### Application for a Non-Material Amendment Following a Grant of Planning Permission

Renovation of existing  
redundant external toilets and storage block into new nursery school classroom  
with amenities. at Fairlands Nursery School, Church Road, Shedfield,  
Southampton, Hampshire, SO32 2HY,

23/00395/FUL

This application adds to the recently Approved Non-Material Minor Amendment 23/02571/NMA

Drawing No: 23-044-203

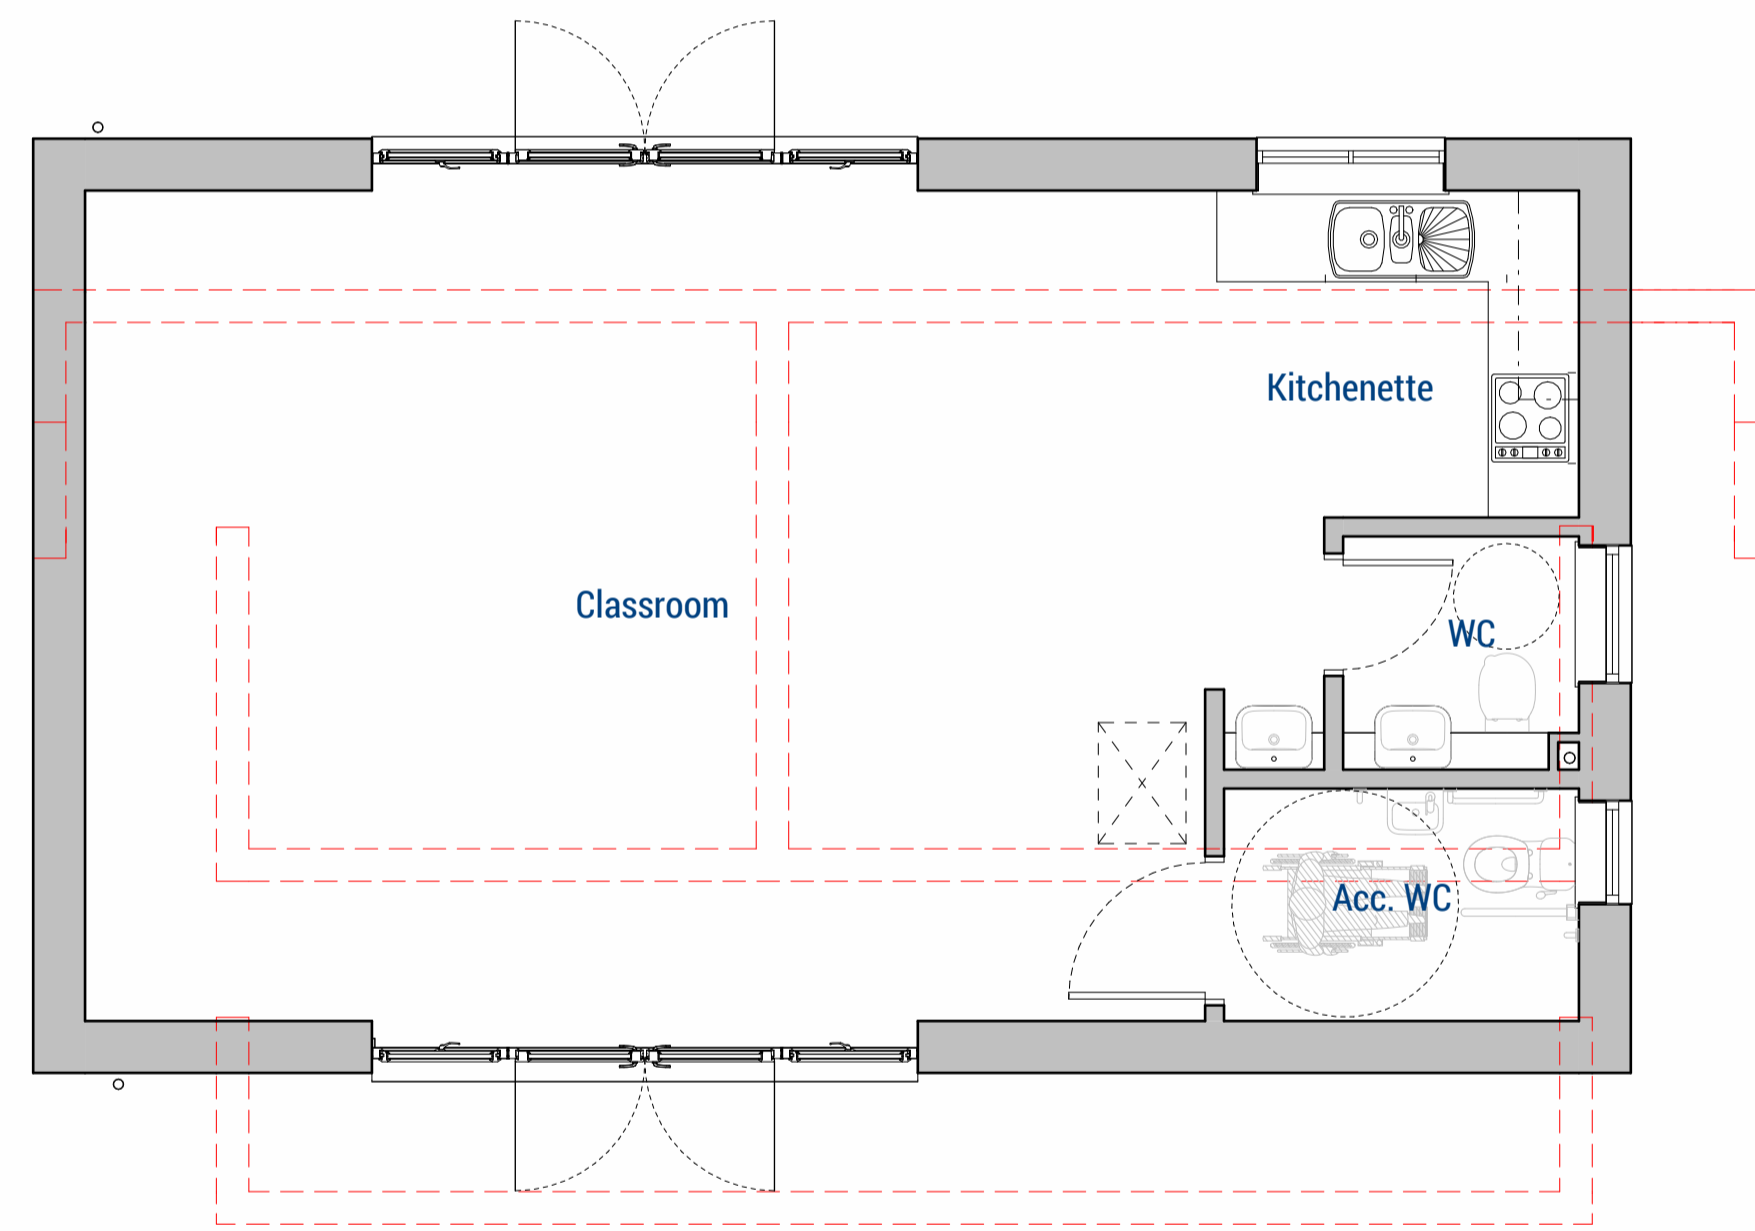
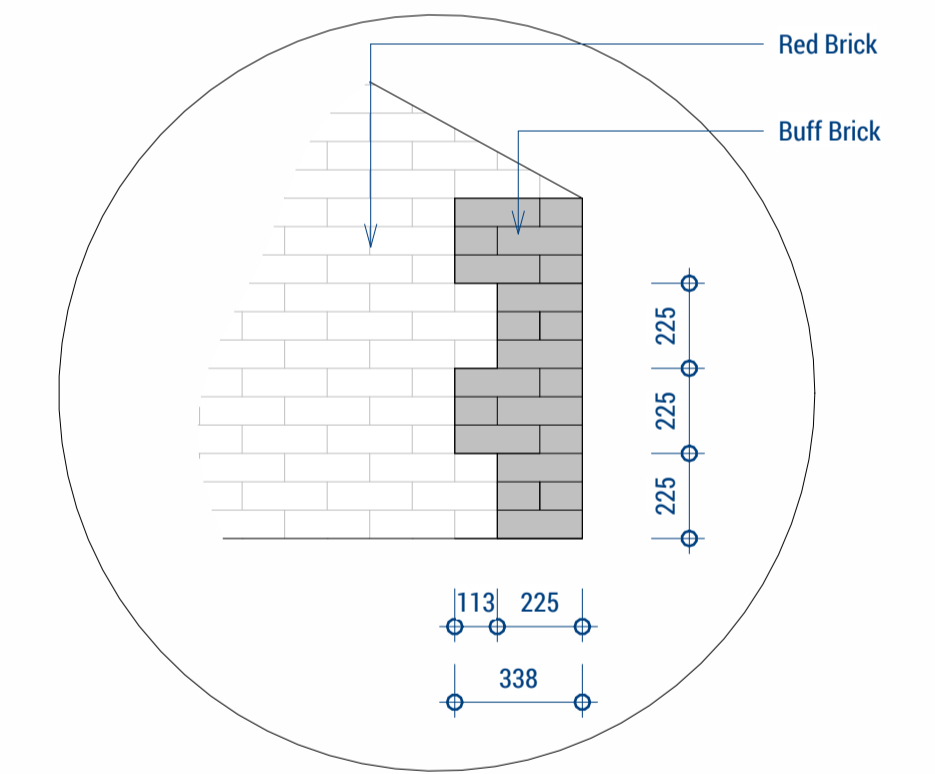
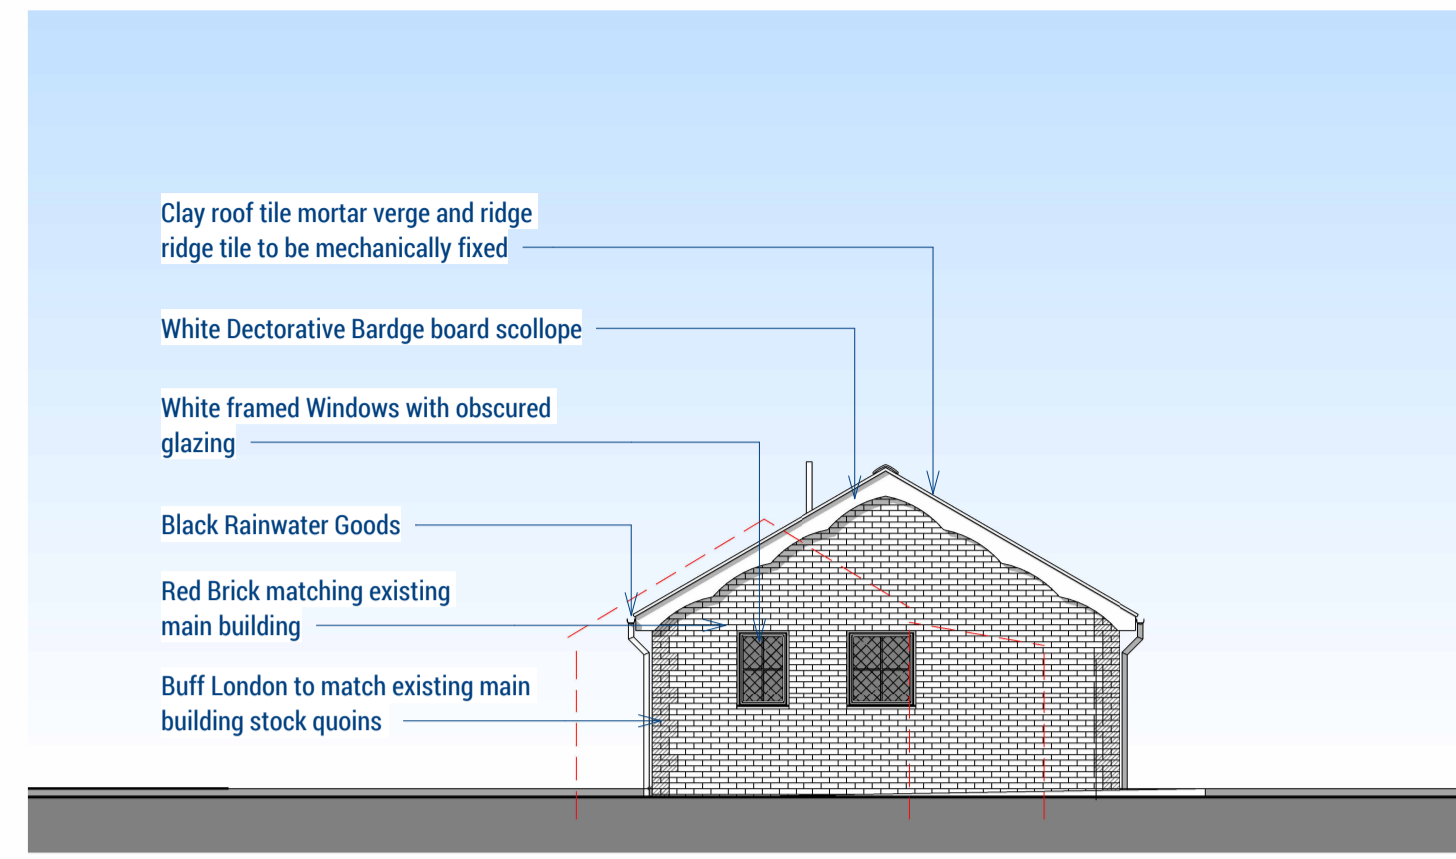
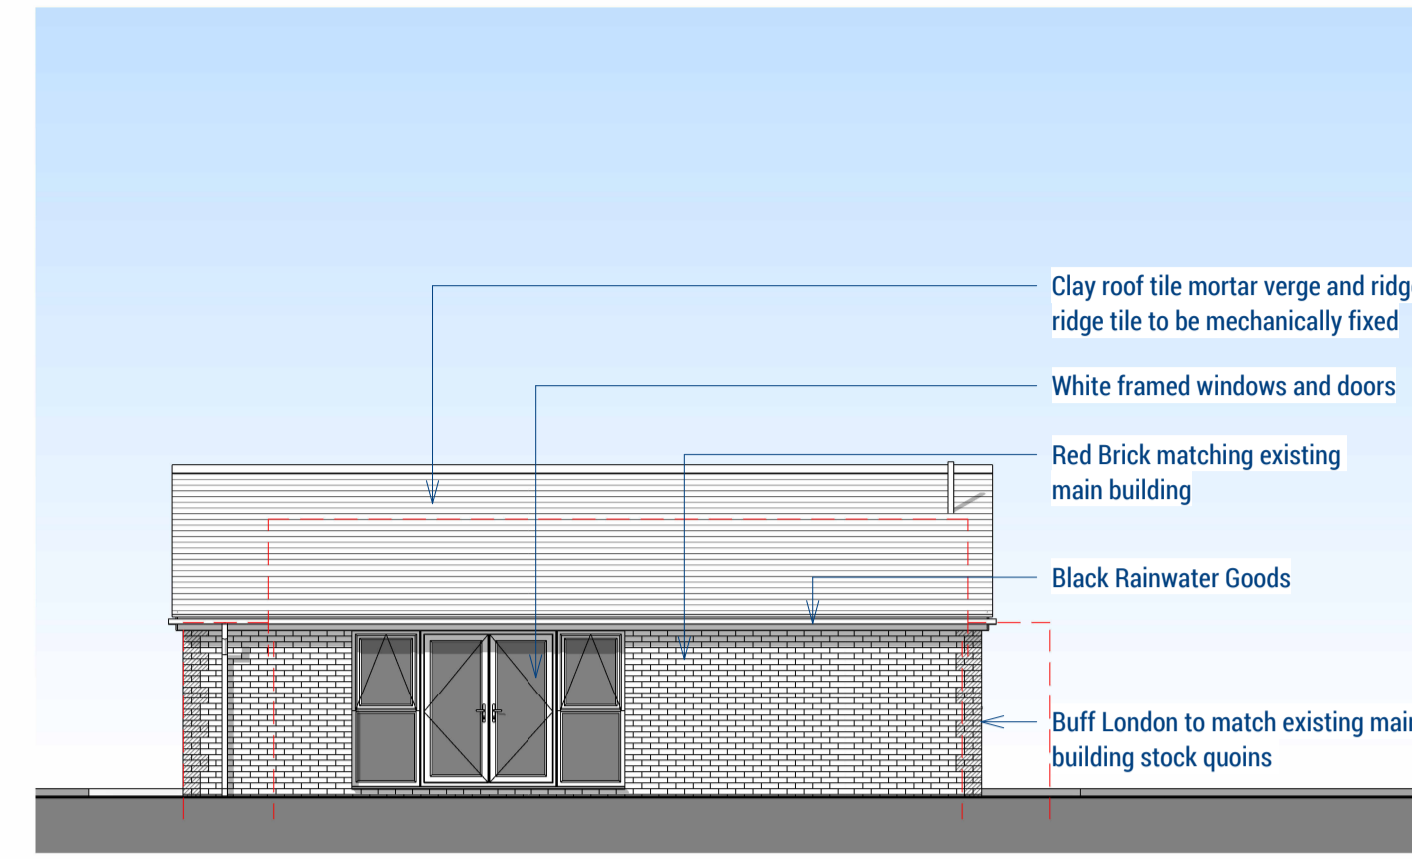
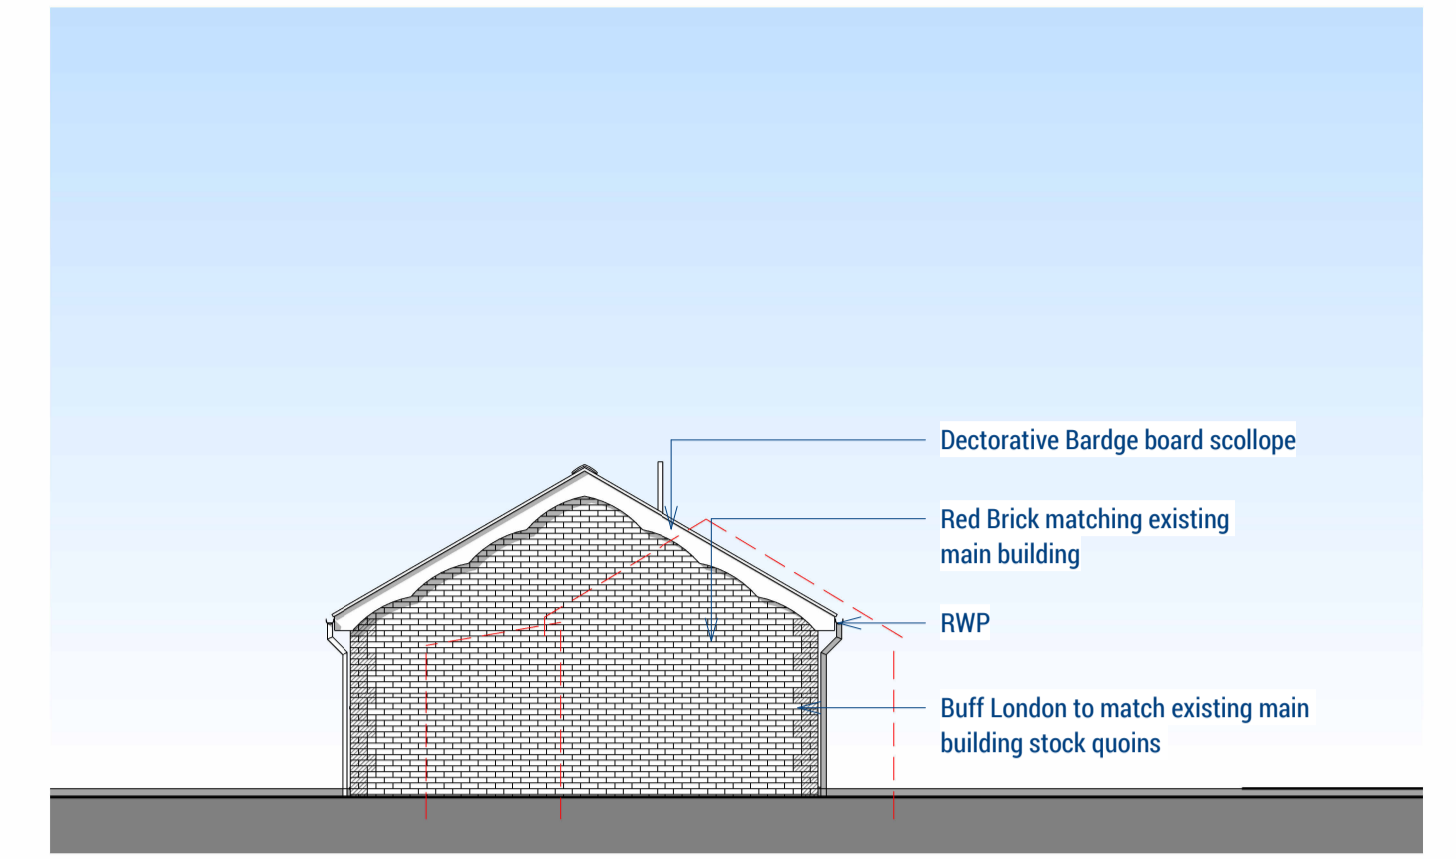
The application proposes to demolish the existing structure and replace it with a new classroom. The proposal is slightly larger than the currently approved but within the existing building footprint.

After further detailed review of the structure and site constraints we would like to locate the new building one meter closer to the existing school building. This will allow for a simpler foundation design and help protect the young oak tree close to proposed building.

23-044 203 Rev A - Plans and Elevations as proposed
